**ADDENDUM NO 2 TO THE FLOODING ASSESSMENTS OF THE  
SHEPHERDS BAY URBAN RENEWAL MASTERPLAN**

As requested we have reviewed the following Stage 1 Project Application plans:

- A 101/7 Basement Plan
- A 102/6 Upper Basement Plan
- A 103/7 Lower Ground Floor Plan
- A 104/5 Ground Floor Plan

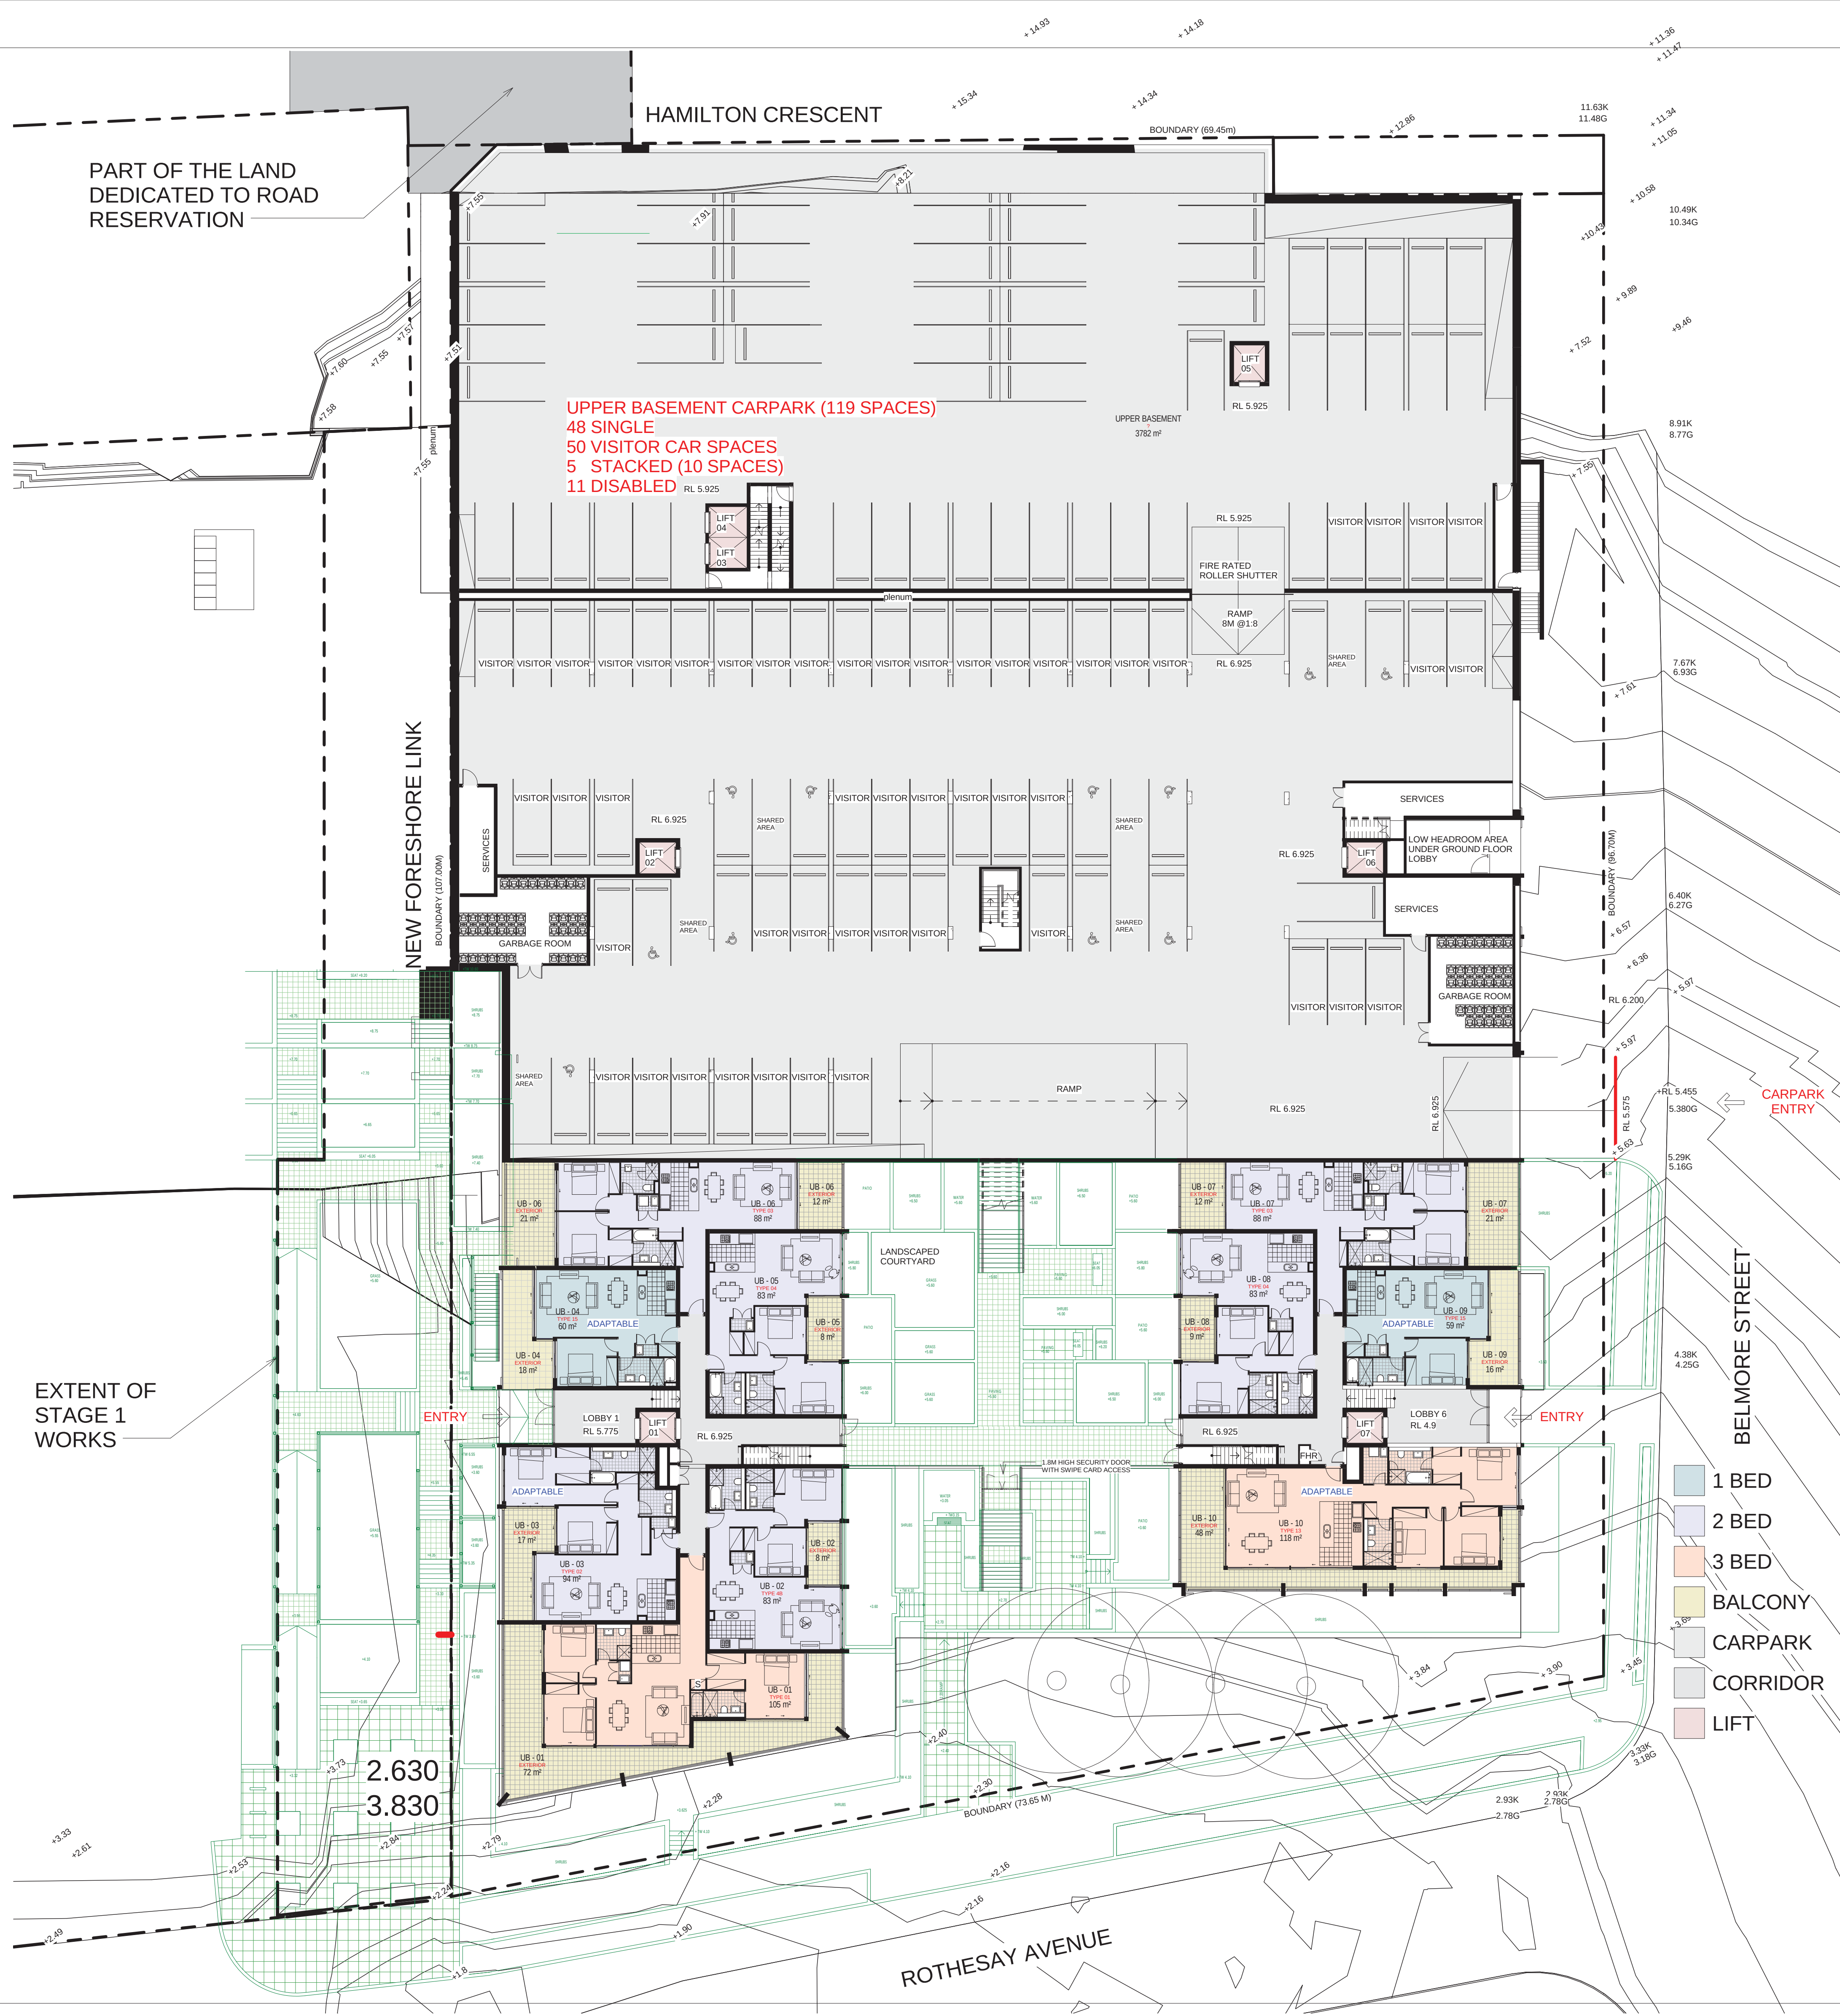
It was assessed that the levels and grades of the entries to the carparking levels from Belmore Street should prevent the ingress of floodwaters into the car parks in a PMF. Likewise it was assessed that the level of lobbies should prevent the ingress of PMF floodwaters into habitable areas.
